Project Name: JM MOORE REALTY COMPANY'S ADDN NO. 1

**May 14, 2008
DRB Comments**

RE: Lots 16-19, J. M. Moore Realty Company Addition No. 1

PLAT OF
LOT 16-A, 17-A, 18-A
J.M. MOORE REALTY COMPANY'S ADDITION No. 1
 WITHIN THE
 TOWN OF ALBUQUERQUE GRANT
 PROJECTED SECTION 17, TOWNSHIP 10 NORTH, RANGE 3 EAST, N.M.P.M.
 CITY OF ALBUQUERQUE
 BERNALILLO COUNTY, NEW MEXICO
 APRIL, 2008

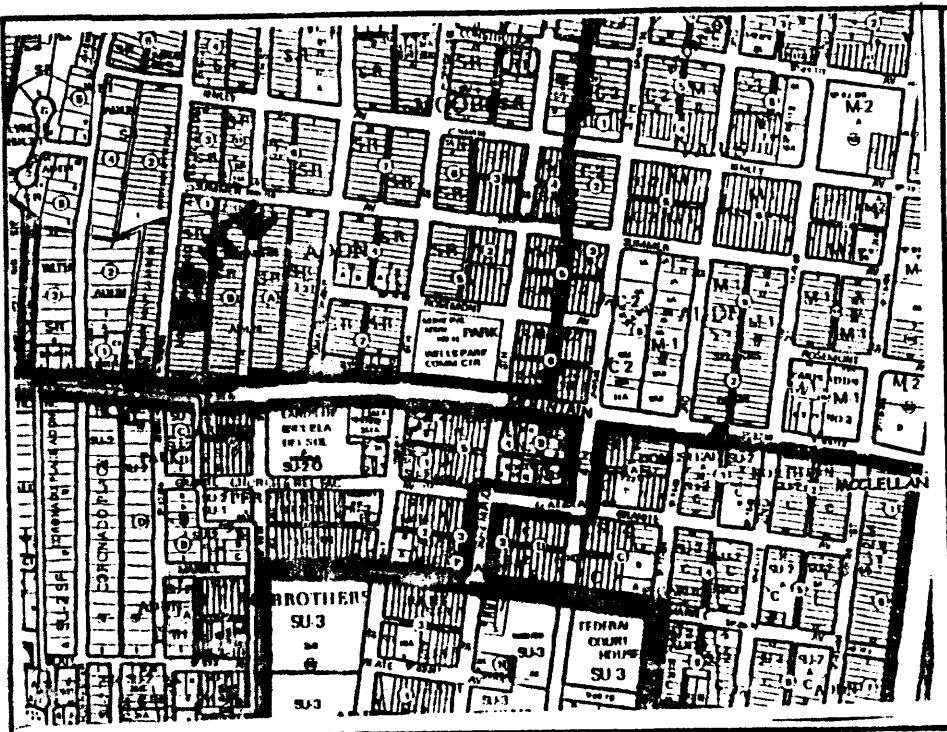
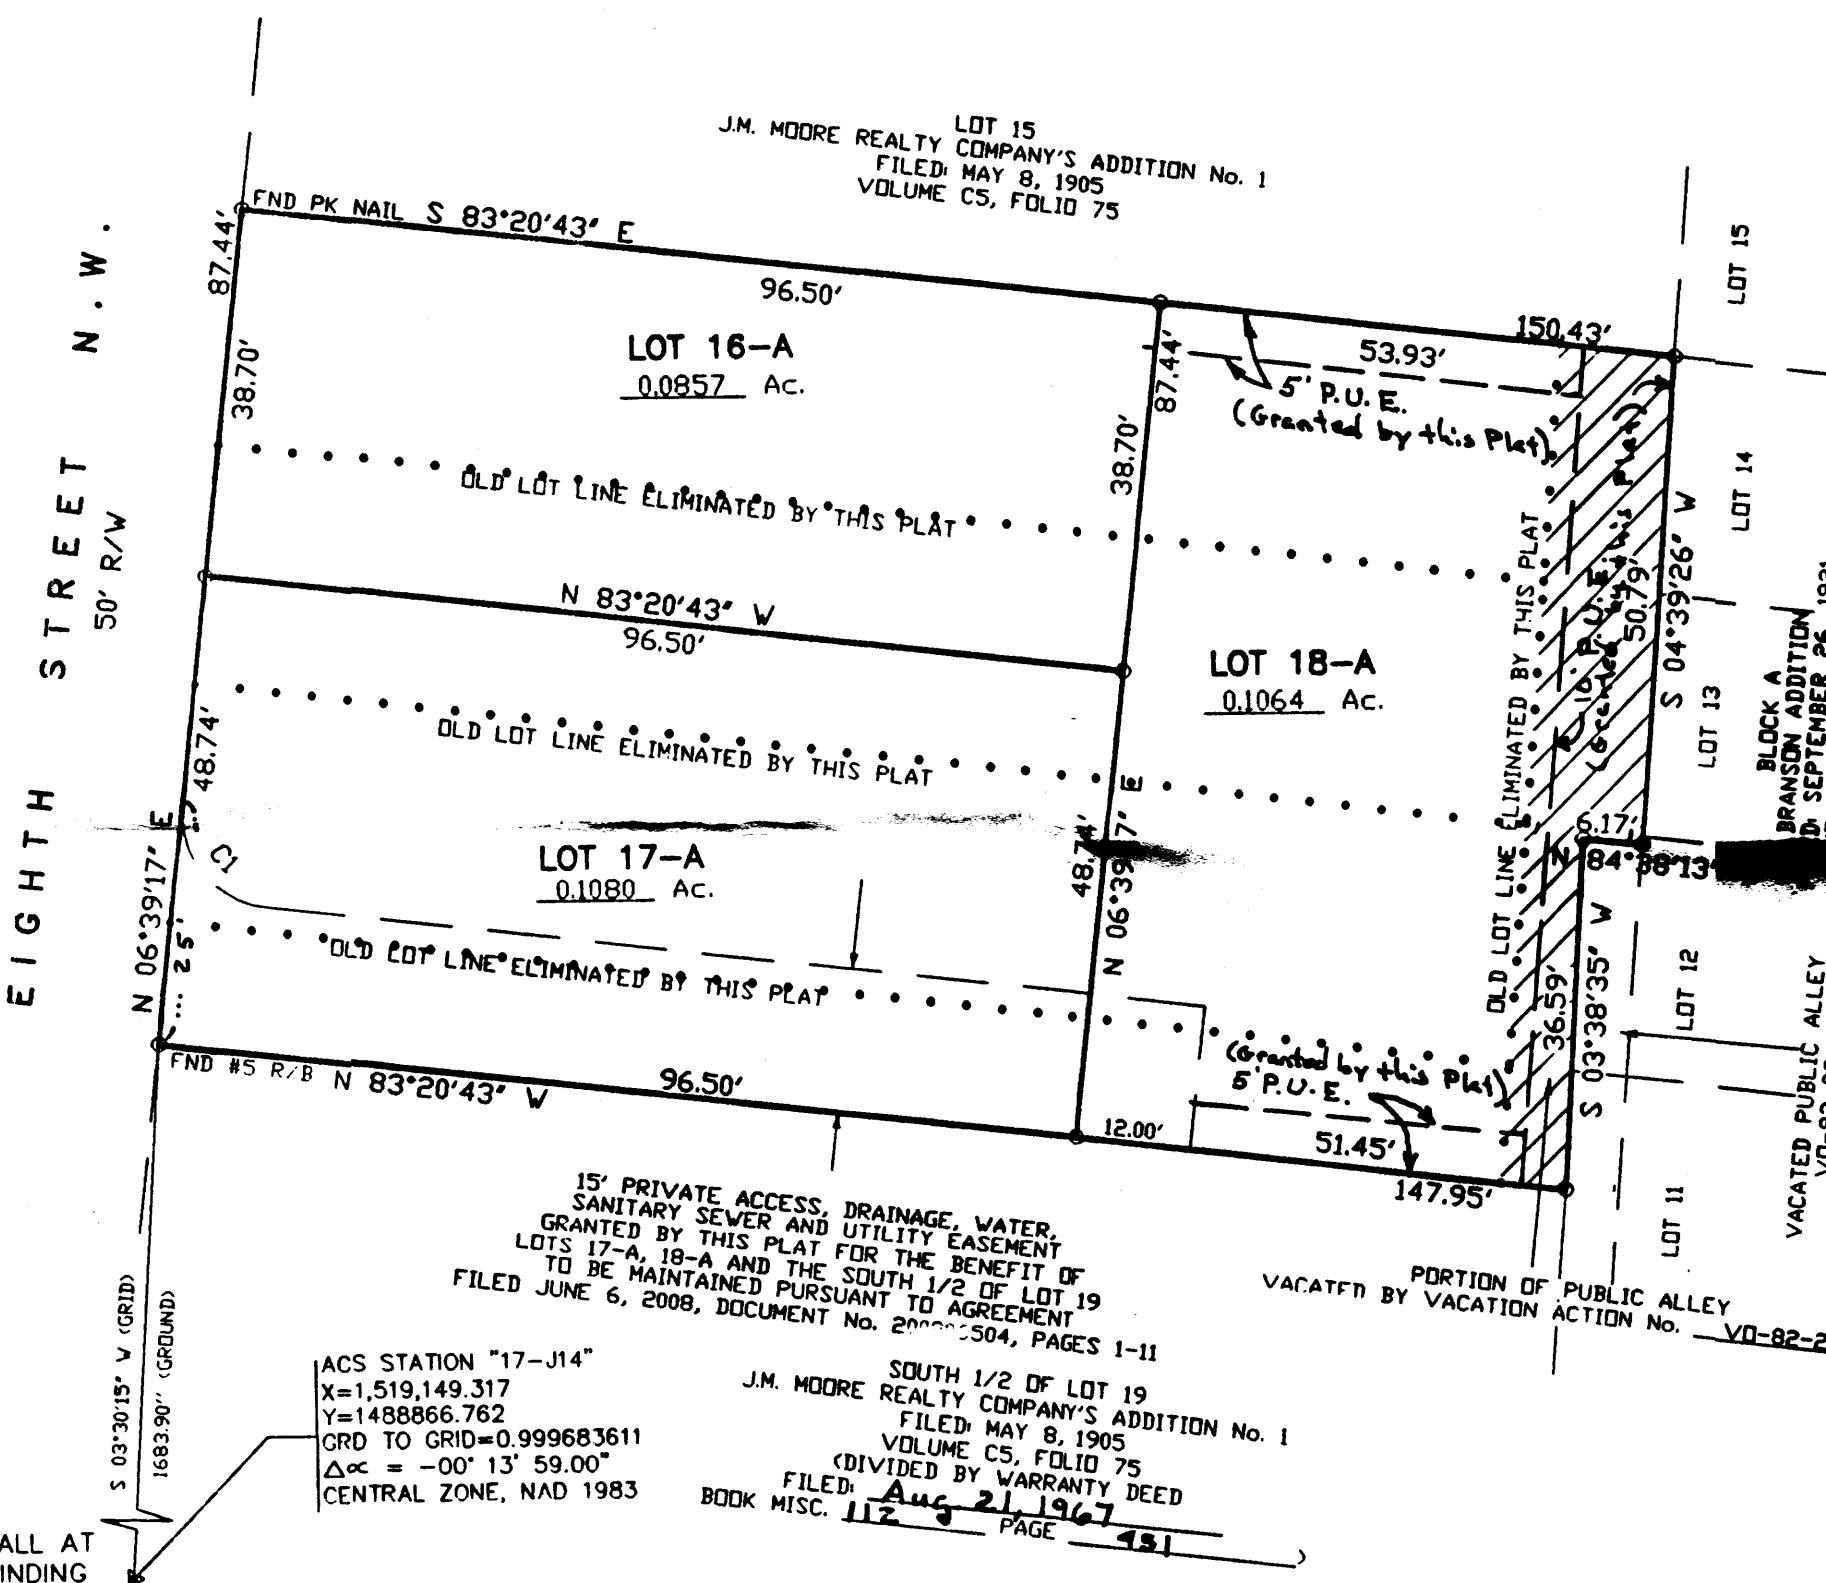
PLANNING (Last to sign): AMAFCA
- clarify Private Easement, incl. drainage

Net lot area (exclusive of access easement - minimum 3,500 sq ft) needs to be noted on the plat. The proposed lot 18-A does not meet the minimum lot area requirements of the S-R zone for two detached dwellings (minimum area of 7,000 sq ft).

For future reference, please do not identify the property's zoning (Note 9) on the plat. Also, please revise solar note (10) to be specific to this type of request, i.e. use the words "THIS PLAT" and not "REQUESTED FINAL ACTION."

A drainage easement is required.

All buildings to be razed.

1) The surveyor is to add to the mylar that the fifteen foot easement is a private access easement pursuant to the easement agreement between the owners of Lots 16,17, 18 as replatted and the owner of the South one-half of Lot 19, and to show that Lots 16 17, and 18 as replatted (and referred to below as "the property") are to have private water and a private sanitary sewer.
